**From:** John Charette <john@charette-design.com>  
**To:** Liv Chase <livchase@yahoo.com>, Tracie Reed <traciereed@dextrouscreative...>  
**CC:** Ann Machado <AMACHADO@portlandmaine.gov>  
**Date:** 8/18/2014 10:13 AM  
**Subject:** Re: 180 Washington Ave - Permit #2014-01749  
**Attachments:** S 1 Structural framing plan.pdf; S 2 Structural framing plan.pdf; S 3 Structural Framing Plan.pdf; A 1.2 Floor Plans.pdf; C 2 Site Plan.pdf

> I have completed my initial zoning review and at this time I can't sign  
> off. I need the following:

A1.1

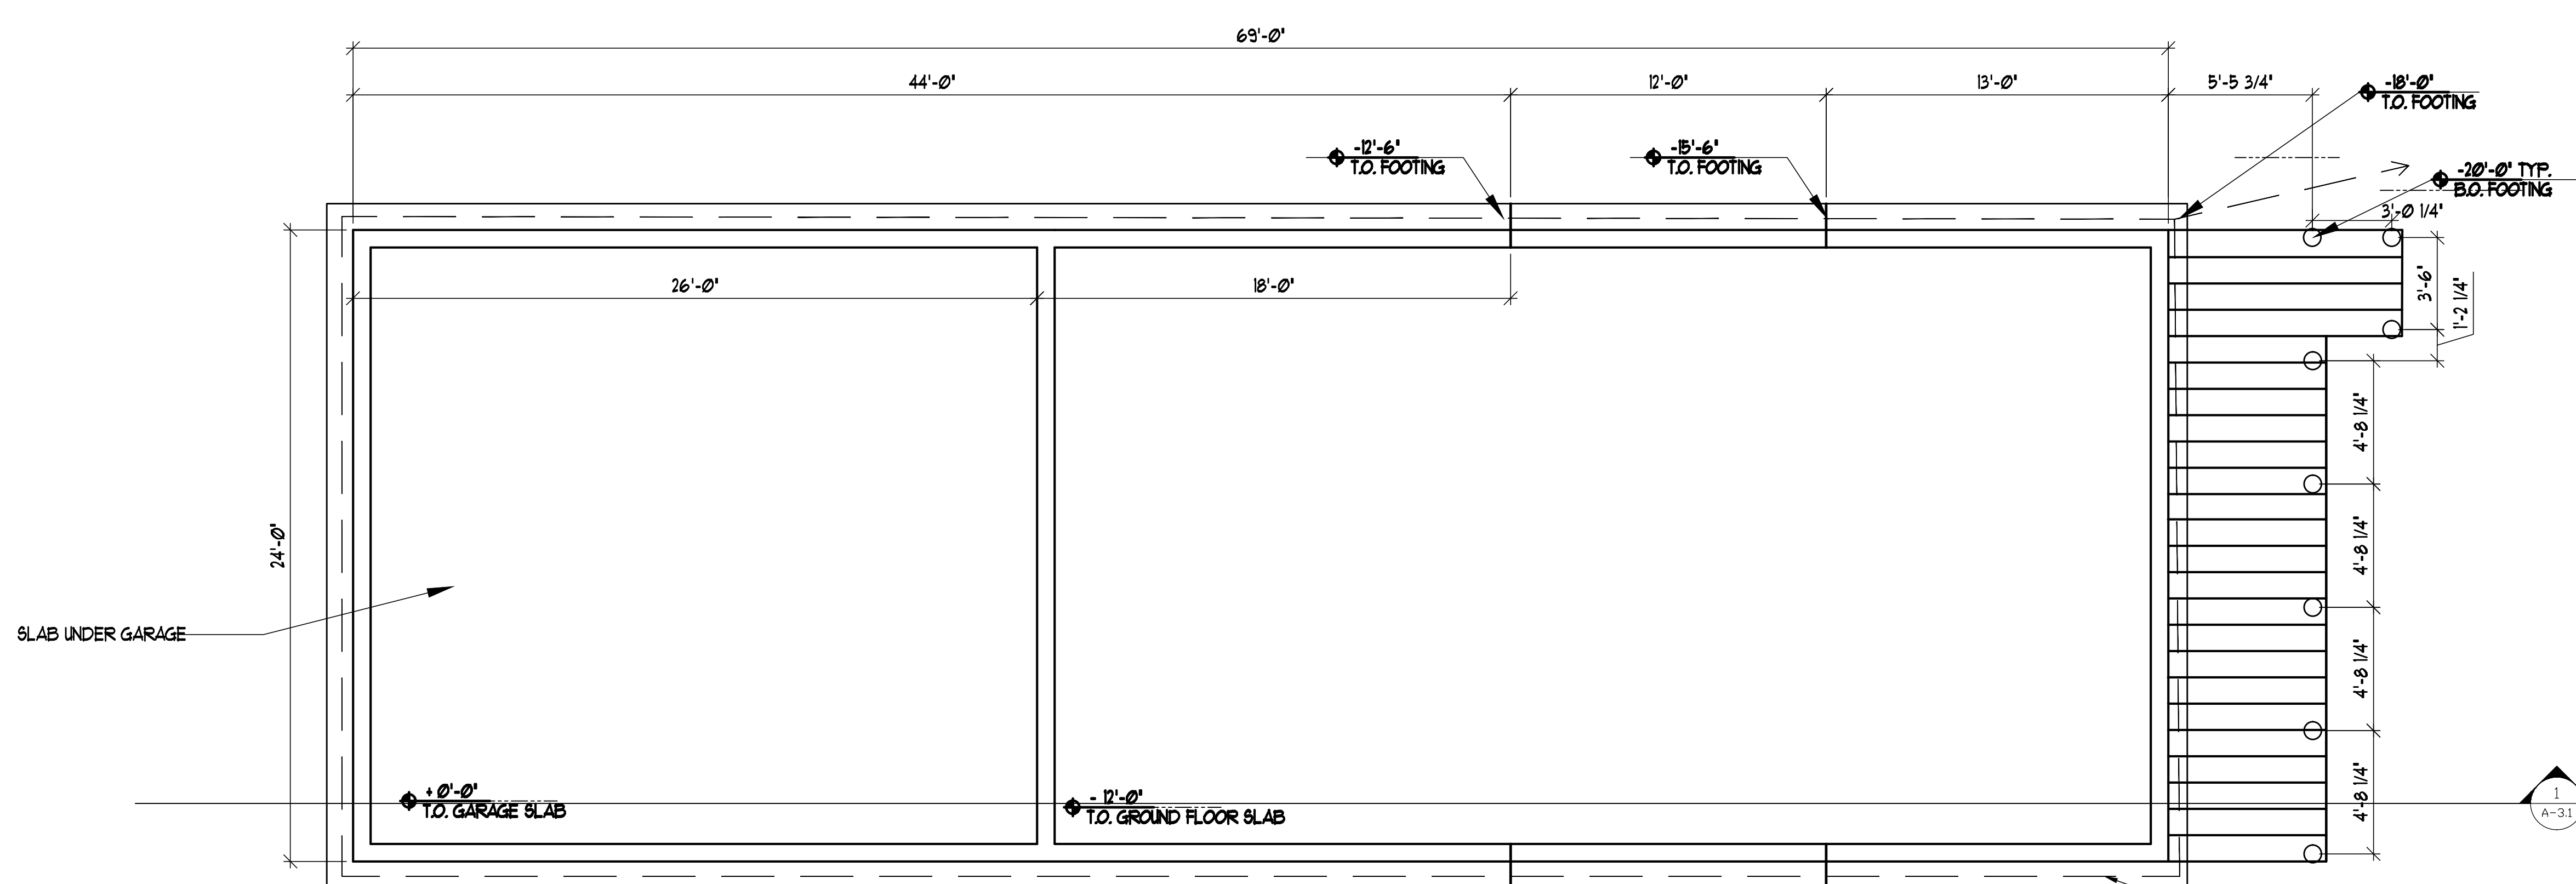
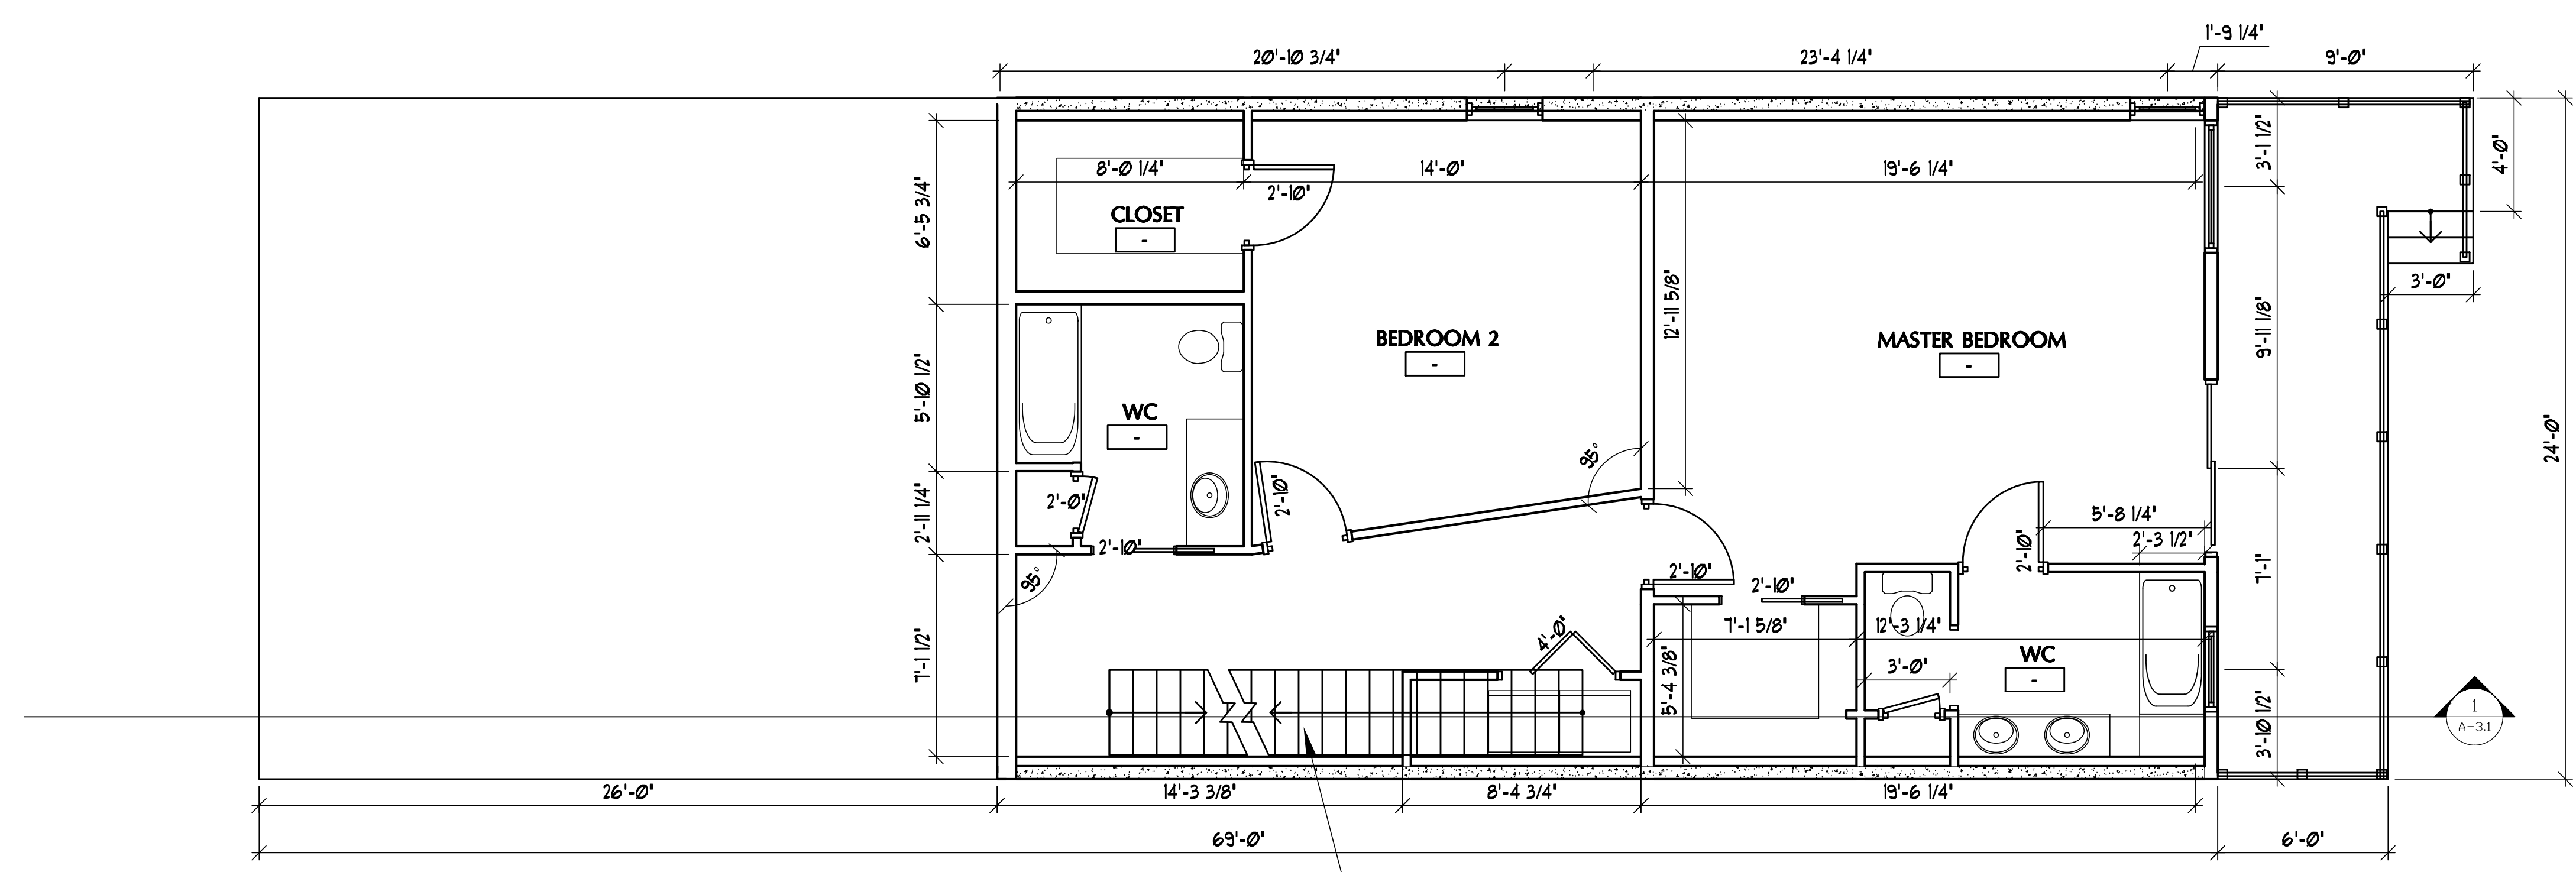
- > 4. There appear to be discrepancies between the floor plans and elevation  
> plans.
    - > -the footprint of the building is 69' x 24'
    - > - the foundation plan and the Ground level plan match these dimensions and  
> what the West elevation shows - the south elevation does not include the  
> deck off the rear of the ground floor

A1.2

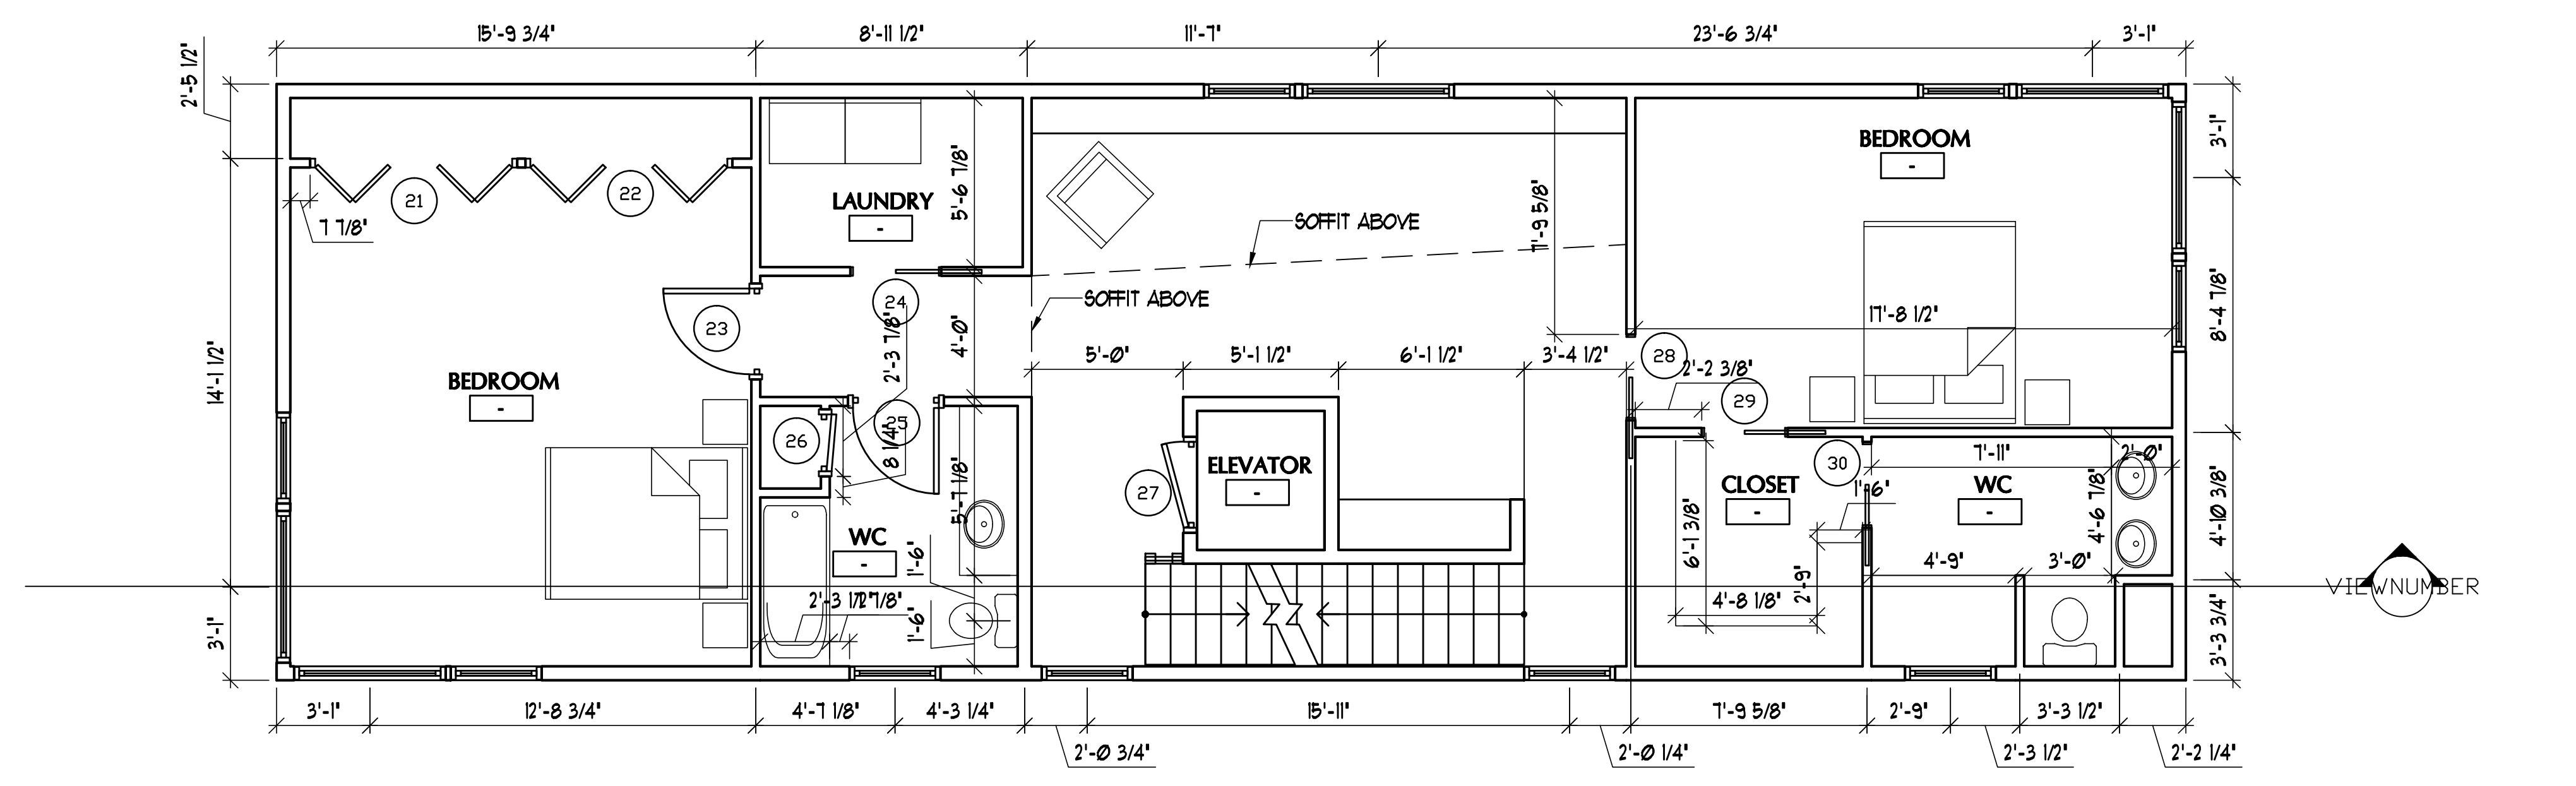
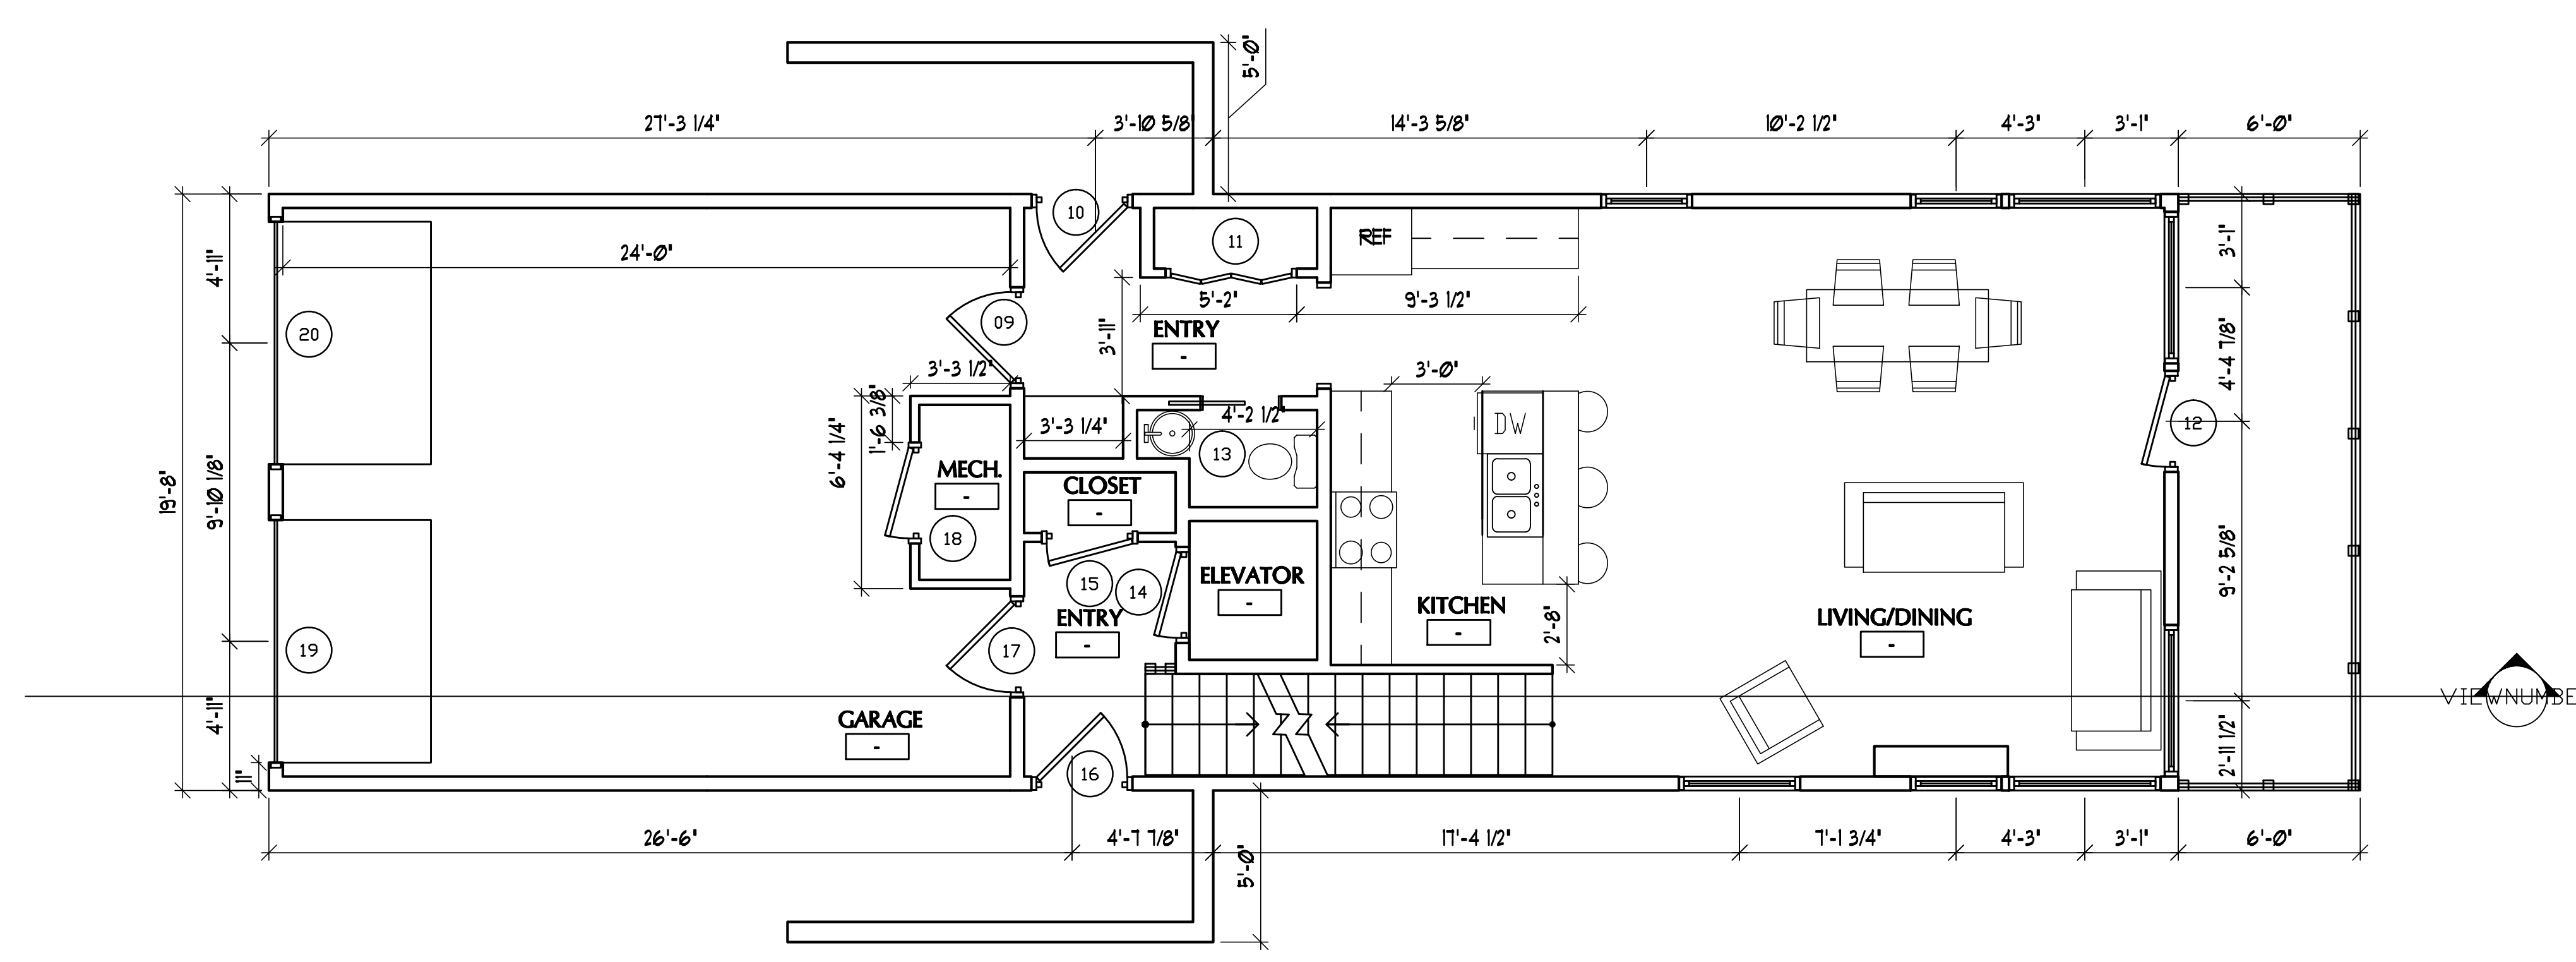
- > - the first floor footprint (A1.2) is 19'8" x 63' with the 6' deck off the  
> back - the West elevation shows the rear as being the full 24' wide - the  
> East elevation shows the front where the garage are as 24' wide - also what  
> are the 5' x 14' extensions off both sides of the building? The building is  
> 24' wide and with 5' extensions coming off both sides the footprint would  
> be 34' wide and the lot is only 29.92' wide - the floor plan also shows a  
> door on the left side which is not on the north elevation.

- > - the second floor footprint is also around 19.7' wide by 63' long - the
- > north and west elevations show a small deck on the right rear corner which

- > is not shown on the floor plan - the north and west elevation also show the
- > building as being 24' wide for the front three quarters of the building,

- > but this is not shown on the floor plan.
- > - the third floor plan matches the elevations.
- > - the framing plans match the elevations and not the floor plan dimensions.

- > 5. The application states that there are three bedrooms in the second unit
- > but the second floor plan only shows two.
- > 6. The North elevation gives the average grade (based on the average of

Ann,  
Attached are revised files including A1.2 floor plans which resolve a great deal of your questions. also attached are revised structural plans and the revised site plan.
